**Subject: Pottinger Wind Farm – SSD-59235464 – Further Transport RFI**

# Pottinger Wind Farm

Barrier/Cobb Highway Temporary Pullover Bay Options  
30/01/2025 **Update 17/03/2025.**

11 (Option 1) - Cobb Highway / Sturt Highway, Hay
Strategic Design
Pottinger Wind Farm

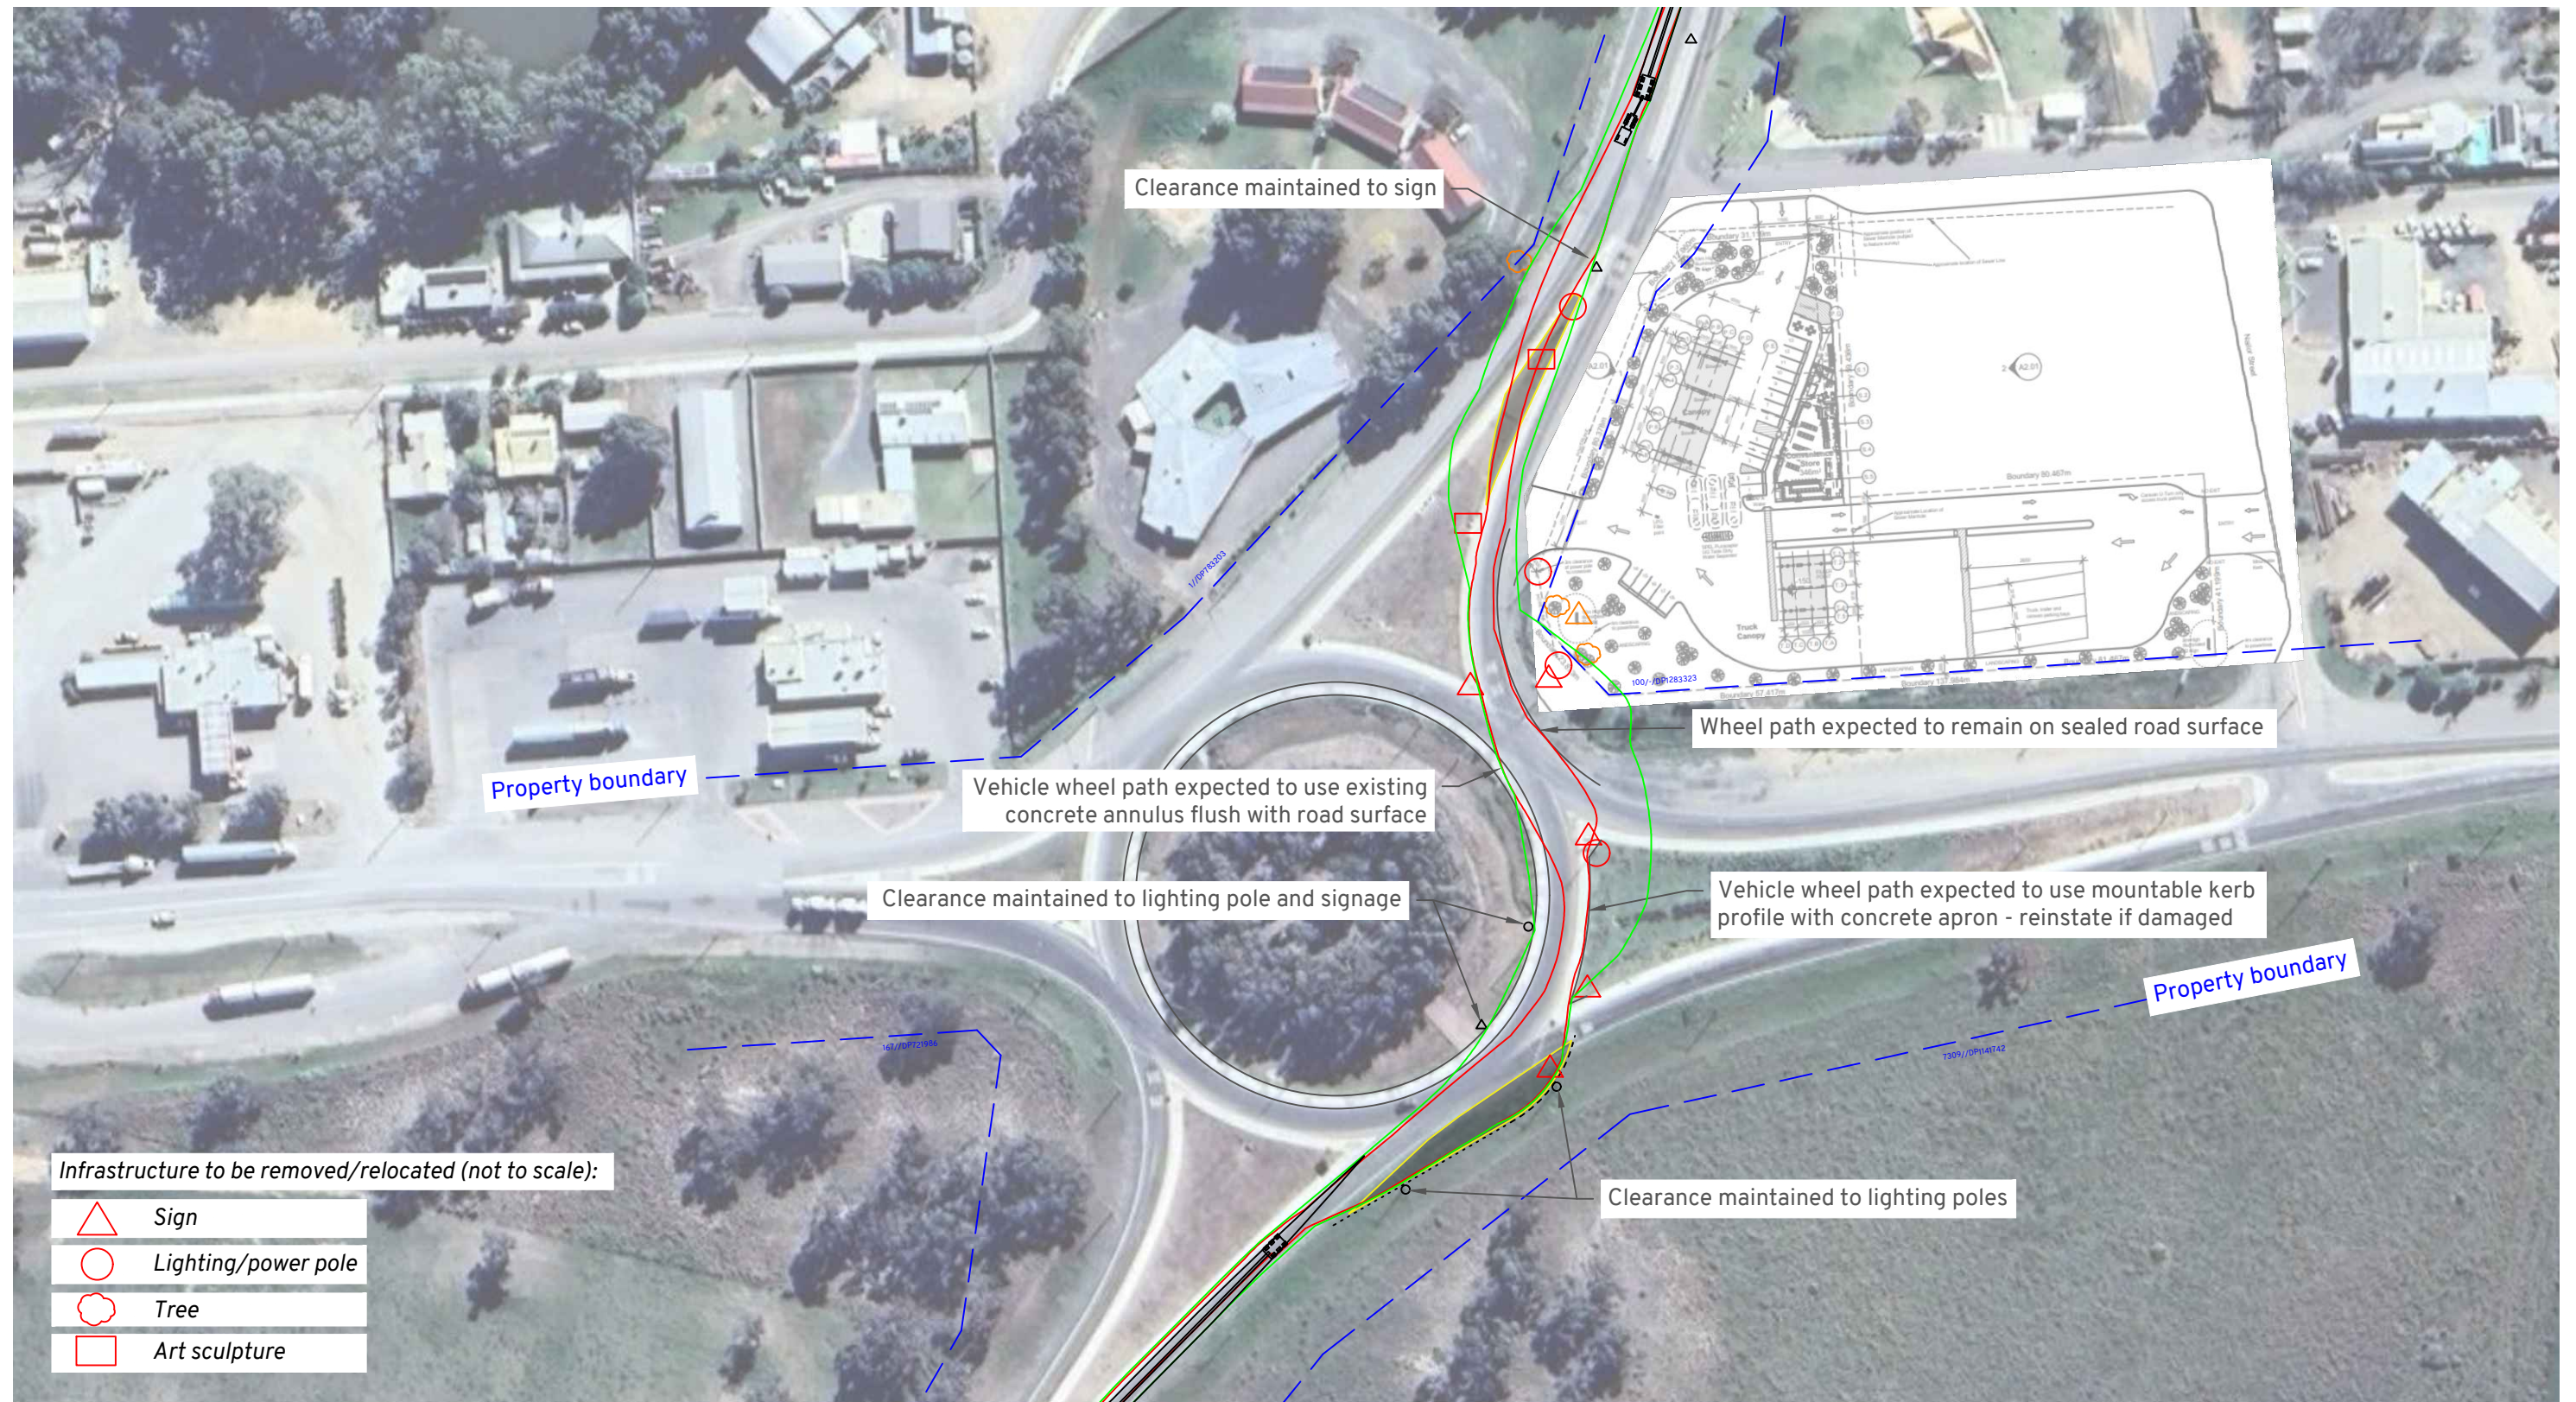
Agency comment	Response
<p>6. The project impacts lighting and power infrastructure at pinch point 11 (1 and 2). The information from Someva on 5 February 2025 does not demonstrate how this infrastructure will be avoided or relocated if impacted by the blade swing. To this point, TfNSW will require further details on how the swept paths of the blade swing will maintain a clearance of 0.5m from the light poles or identify within revised strategic designs (if this cannot be achieved) the removal and relocation of the light poles to a location that the blade swing will not impact.</p>	<p>As per the RFI response dated 13/2/2025 and as confirmed in previous meetings and correspondence with TfNSW, the Project has confirmed that the OSOM vehicle body will avoid the lighting and power infrastructure. The wheel path is expected to use a mountable kerb profile with a concrete apron as identified on the updated strategic design. Updated aerial imagery has been used by Amber in previous responses for Pinch Point 11 options 1 and 2 to provide greater clarity.</p> <p>The Project accepts that 0.5m clearance should be provided as part of final swept path assessments on the blade length selected and transport vehicles used to transport this equipment and is accepting of this as a condition.</p>
